Fire Marshal Division

RE: WH Place Retail and Business Center
NC 210 South at Sandclay Rd.
Bunnlevel, NC

Application Number BCOM2007-0007

**SITE PLAN**

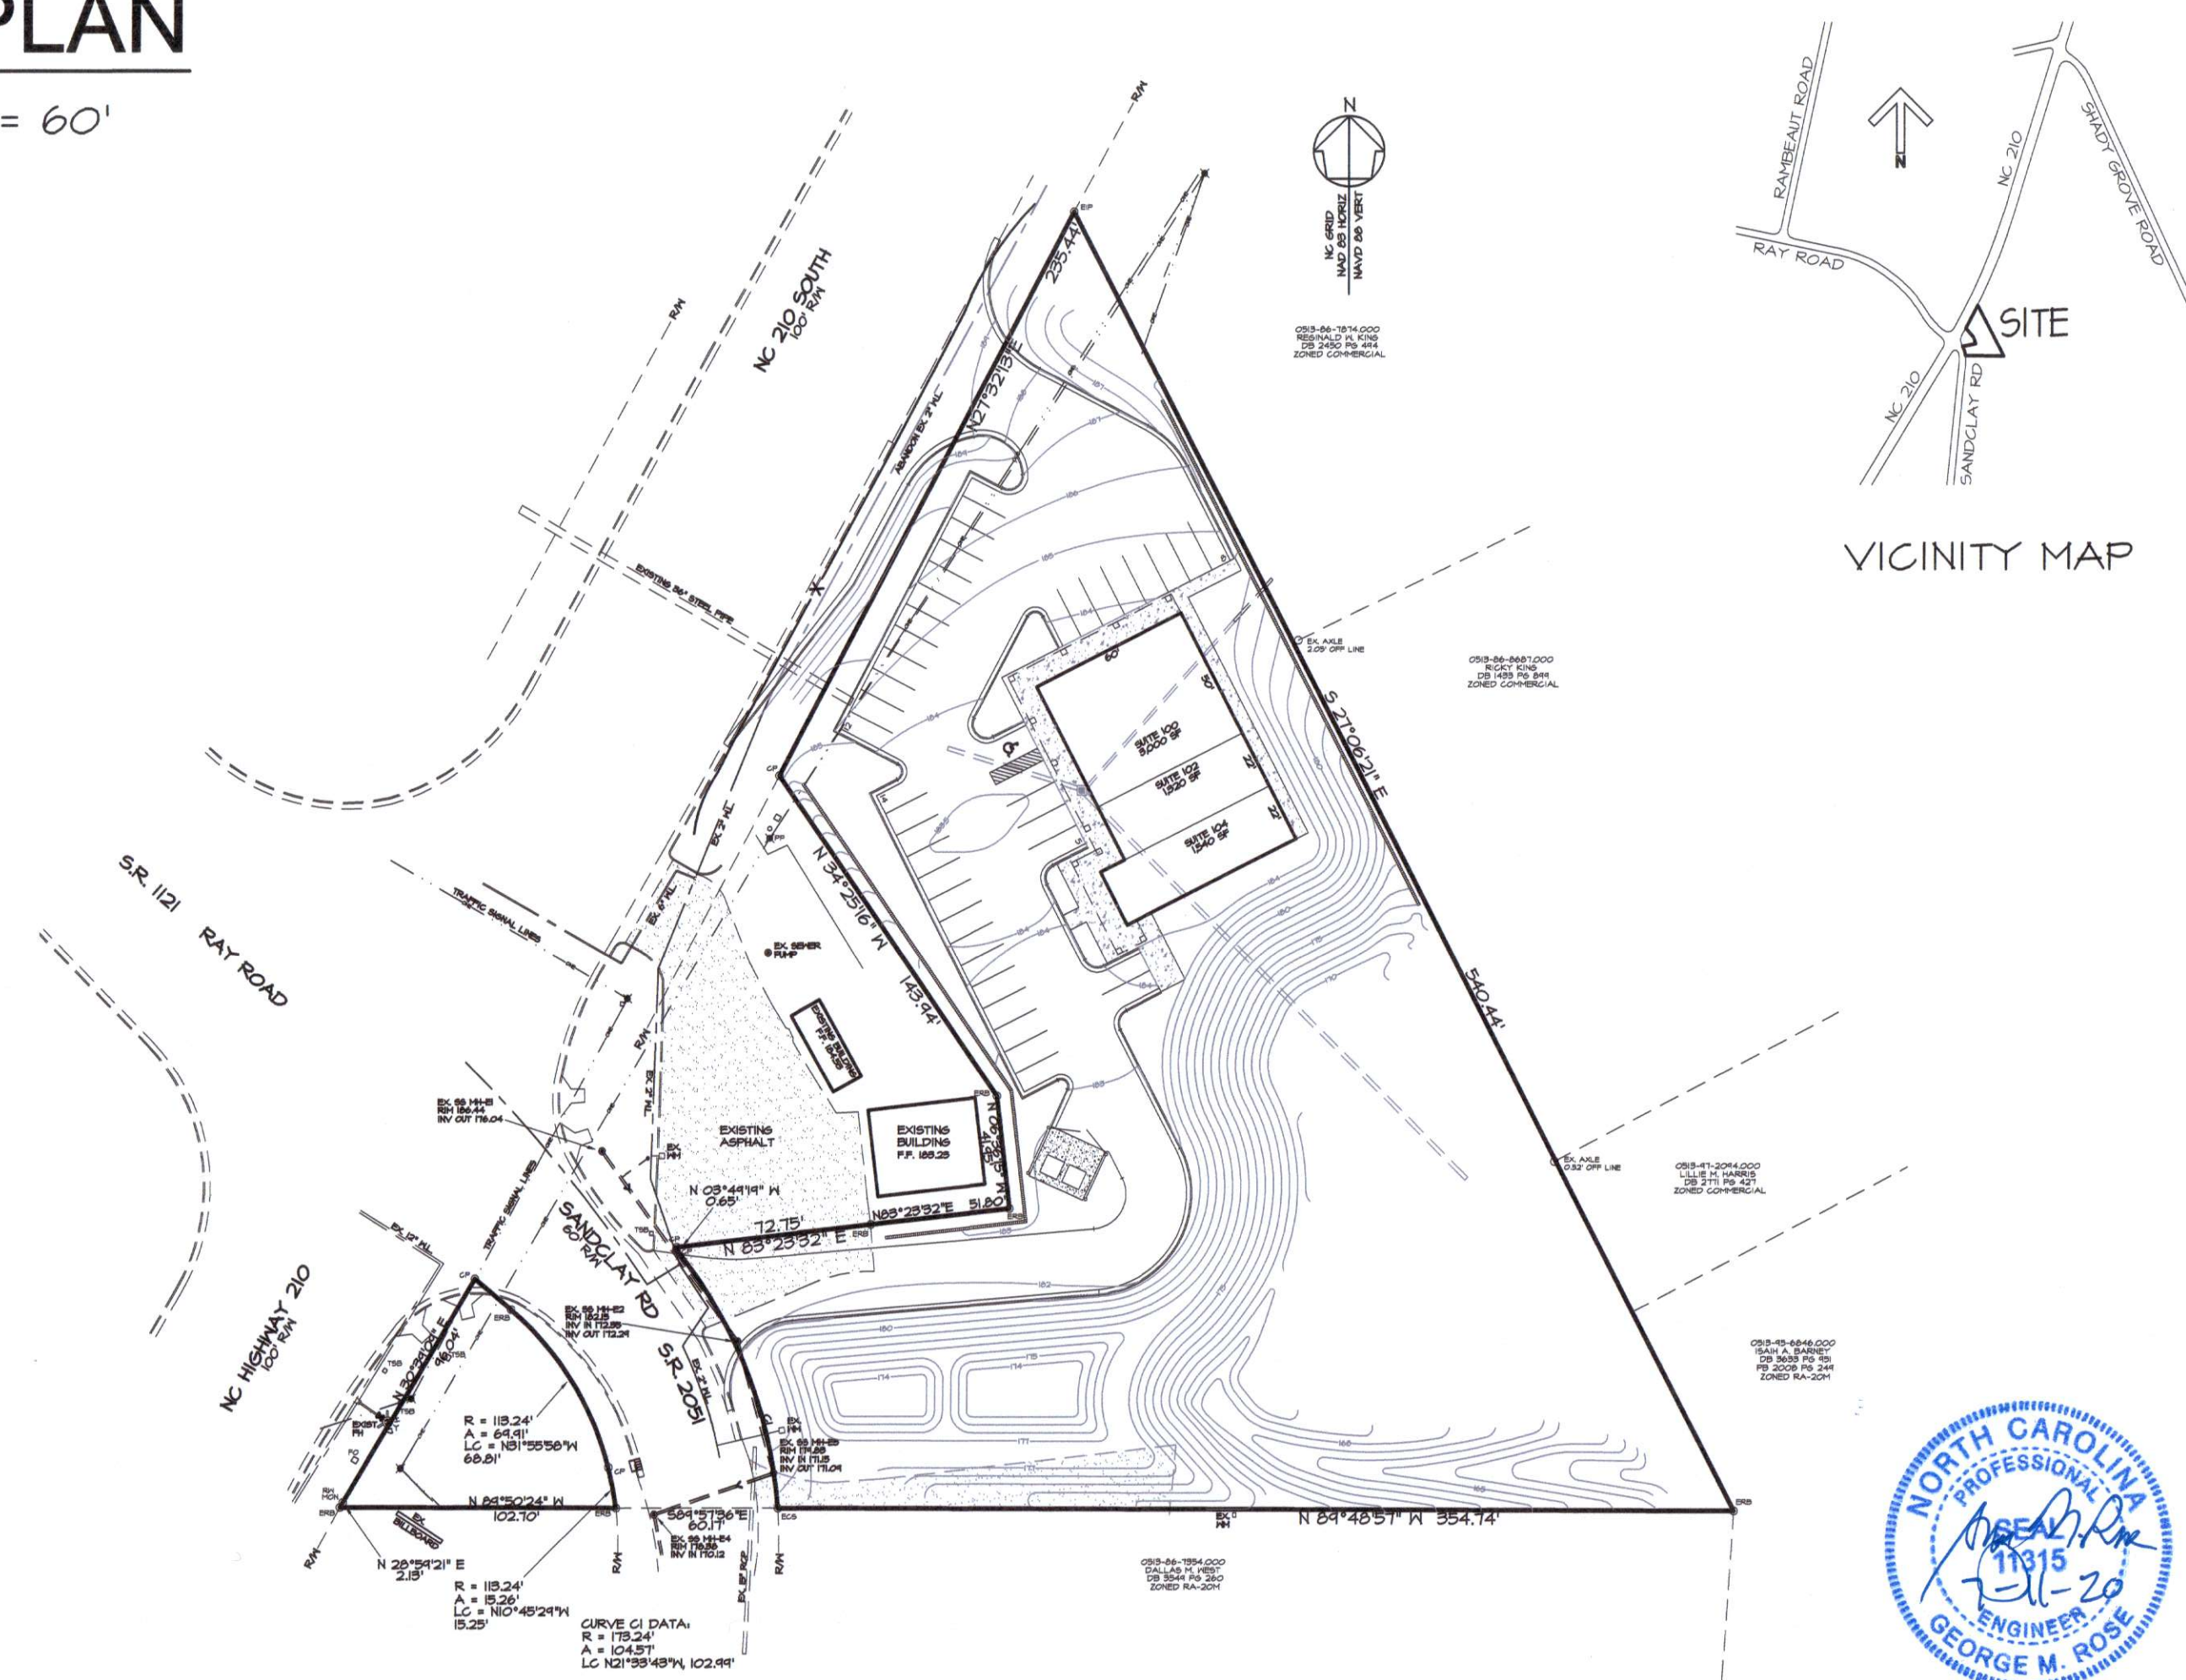
- **Physical Address**
 - The physical address of the building shall be posted in a conspicuous place so that it can be seen on approach from the road, access road, and/or parking lot.
 - The numbers used to make up the physical address shall be at least 6 inches in height.

- **Fire Department Access**
 - The fire department access shall extend to within 150 feet of all portions of the facility.

**LIFE SAFETY/EGRESS PLAN**

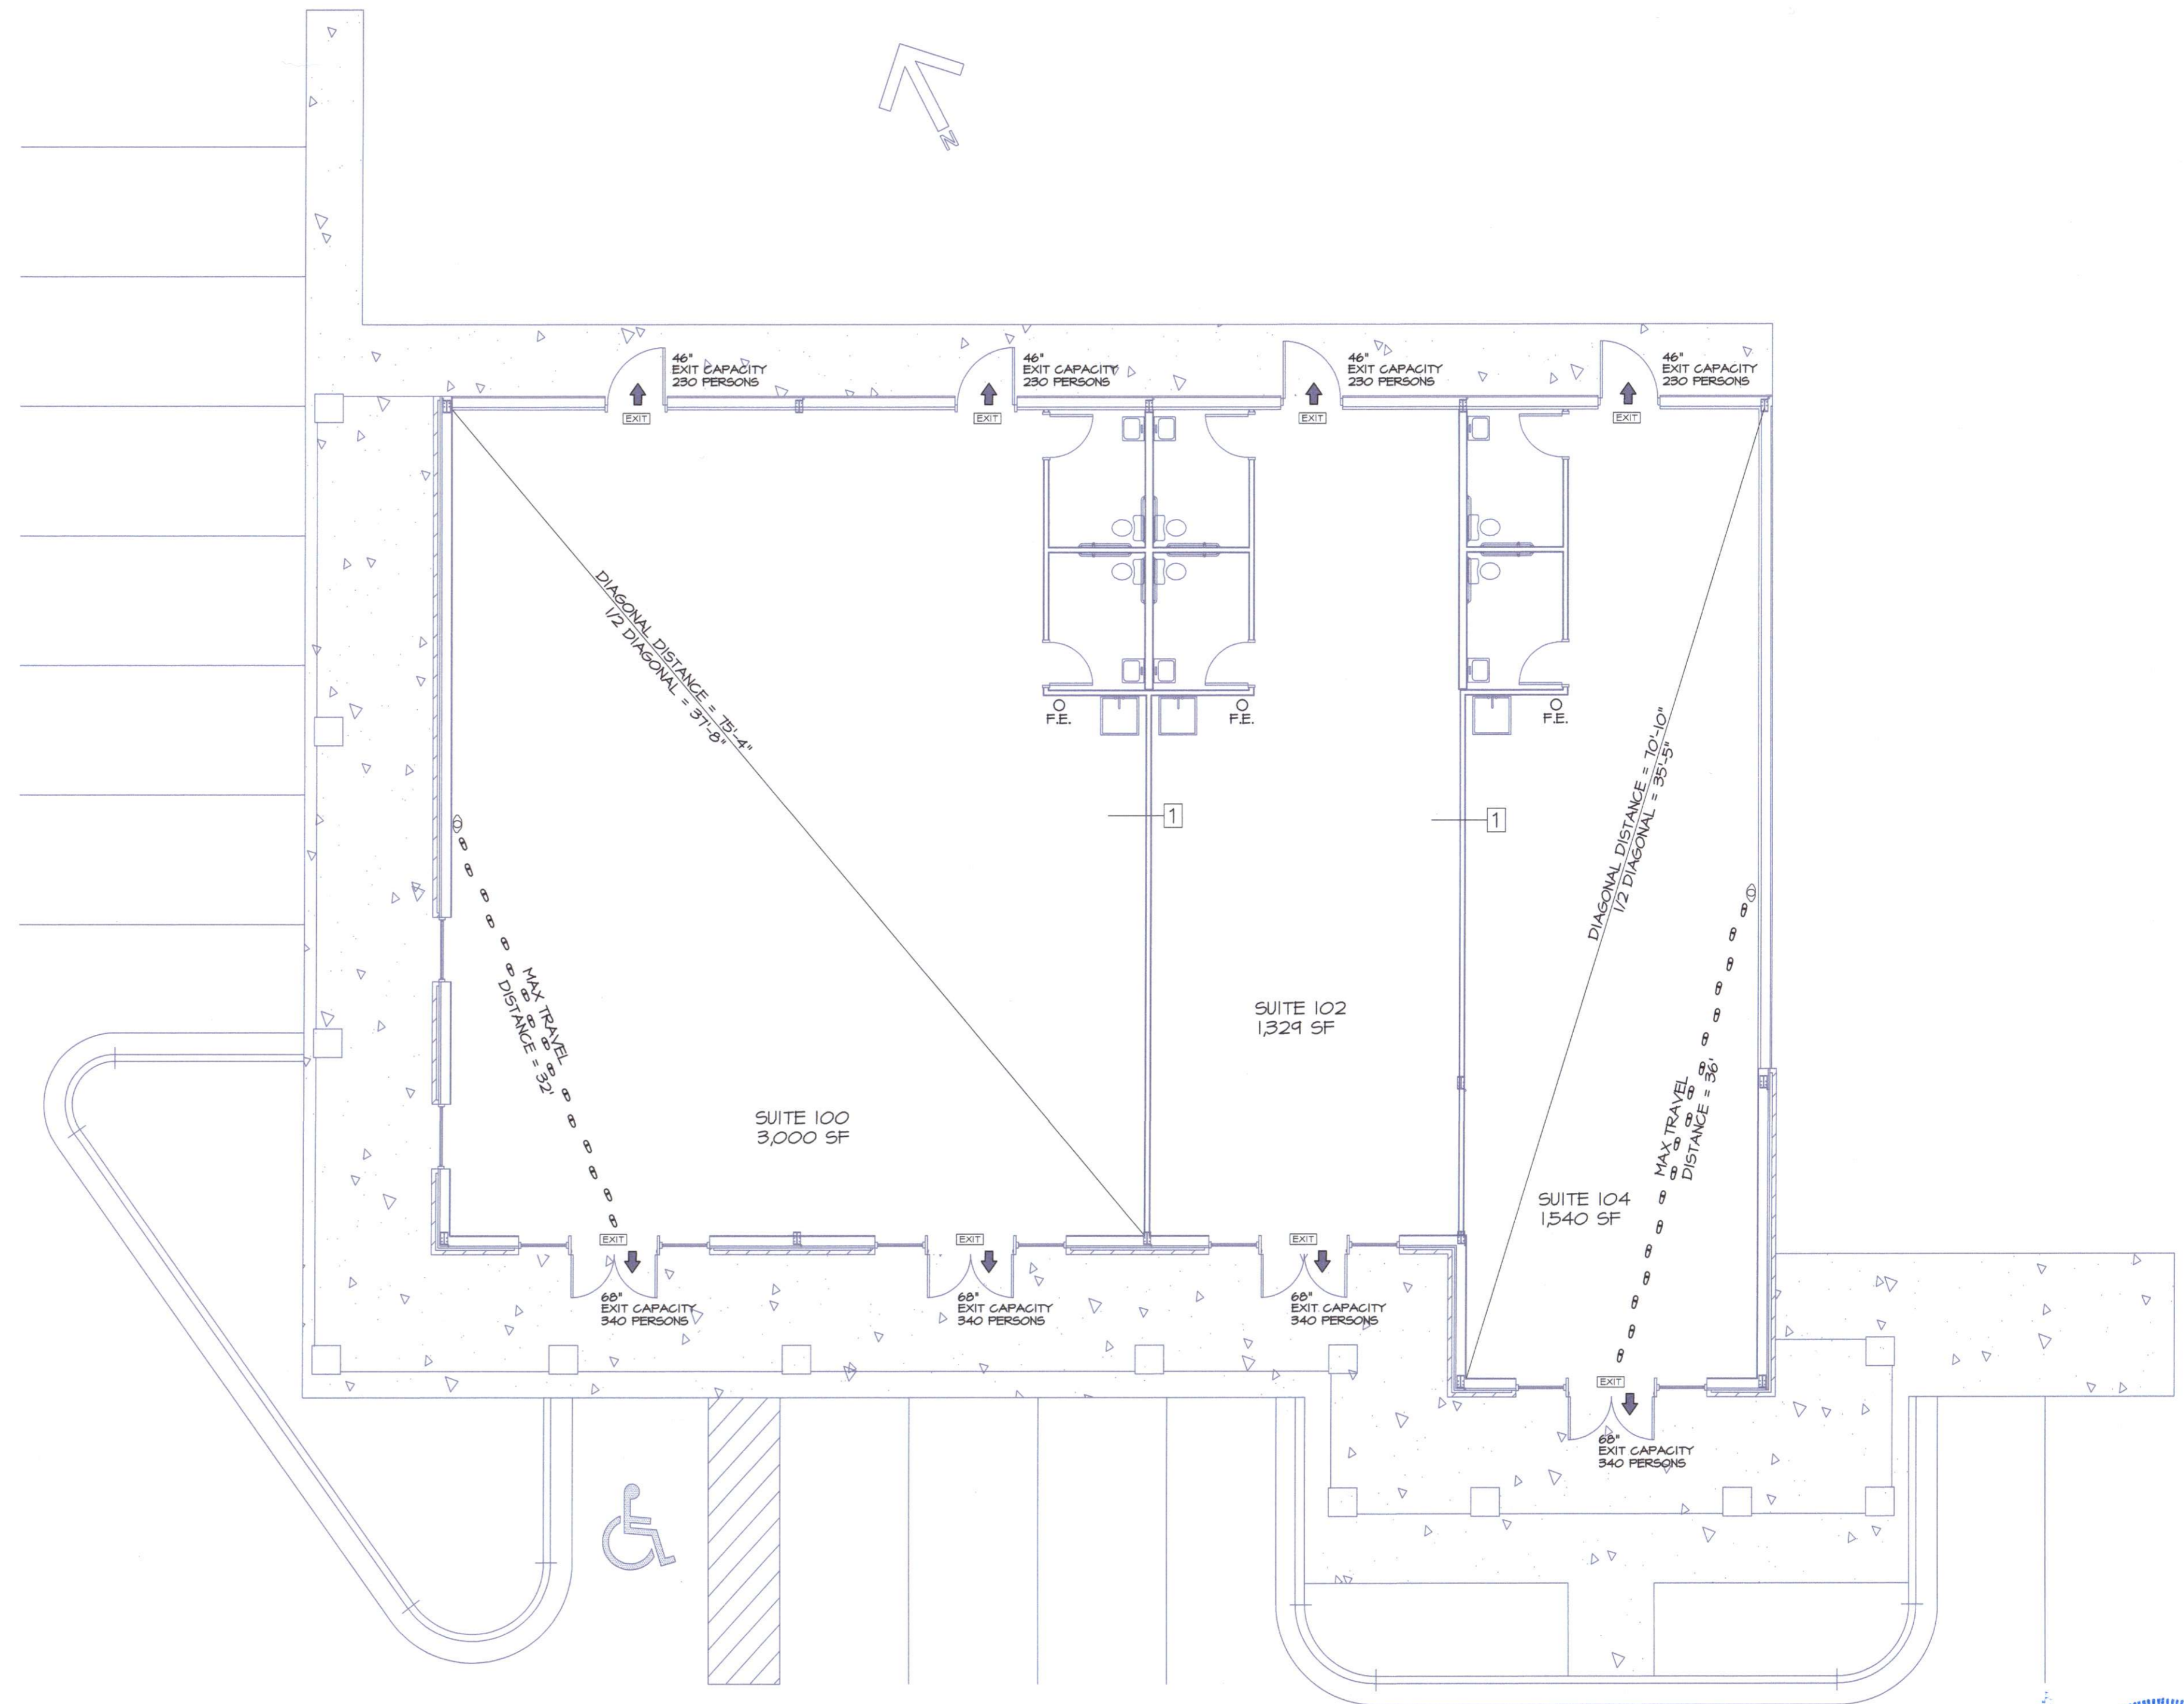
- **Fire Extinguishers**
 - Fire Extinguishers shall be 2A:10BC and shall be placed with a travel distance to not exceed 75'
 - Fire extinguishers are to be mounted no higher than 5' above the finished floor.
